Your ref: SSD-68013714
Our ref: DOC25/182740

Subject: Environmental Impact Statement – 43-61 Turner Road Data Centre (SSD-68013714)

CPHR advice on EIS – 43-61 Turner Road Data Centre (SSD-68013714)Documents Reviewed

Figure 3-2 Landscaping plan

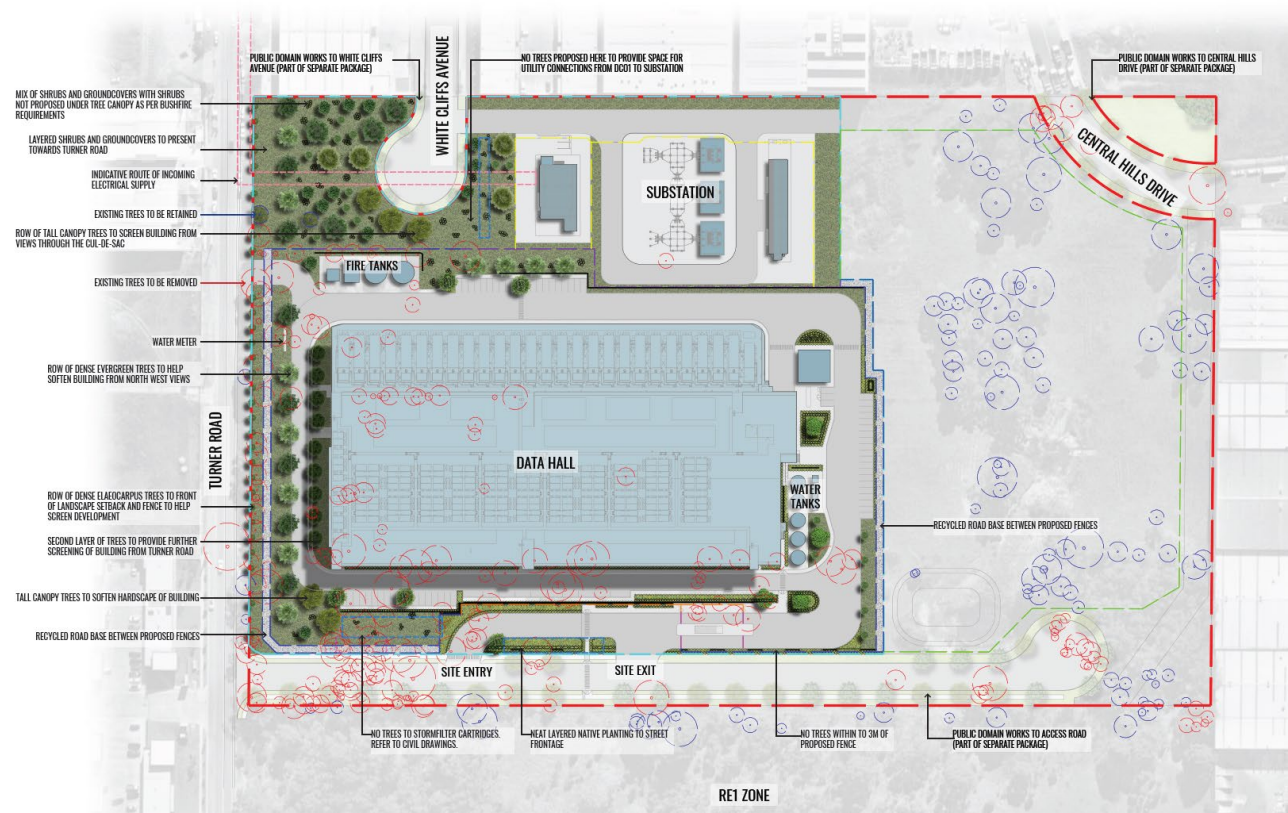
4.	<i>Landscape Plan</i>	<p>The SEARs requirements under Item 7 Trees and Landscaping includes the provision of a detailed site-wide landscape plan. CPHR notes the provided landscape plan only shows proposed plantings for part of the subject site. No plantings are proposed for the northern section of the subject site.</p> <p>Recommended actions:</p> <p>4. CPHR requests further information to understand why the landscape plan does not include proposed plantings for the northern section of the subject site.</p>
	<i>Extent and Timing</i>	<p>Pre-determination</p> <p>At Response to Submissions stage before determination.</p>
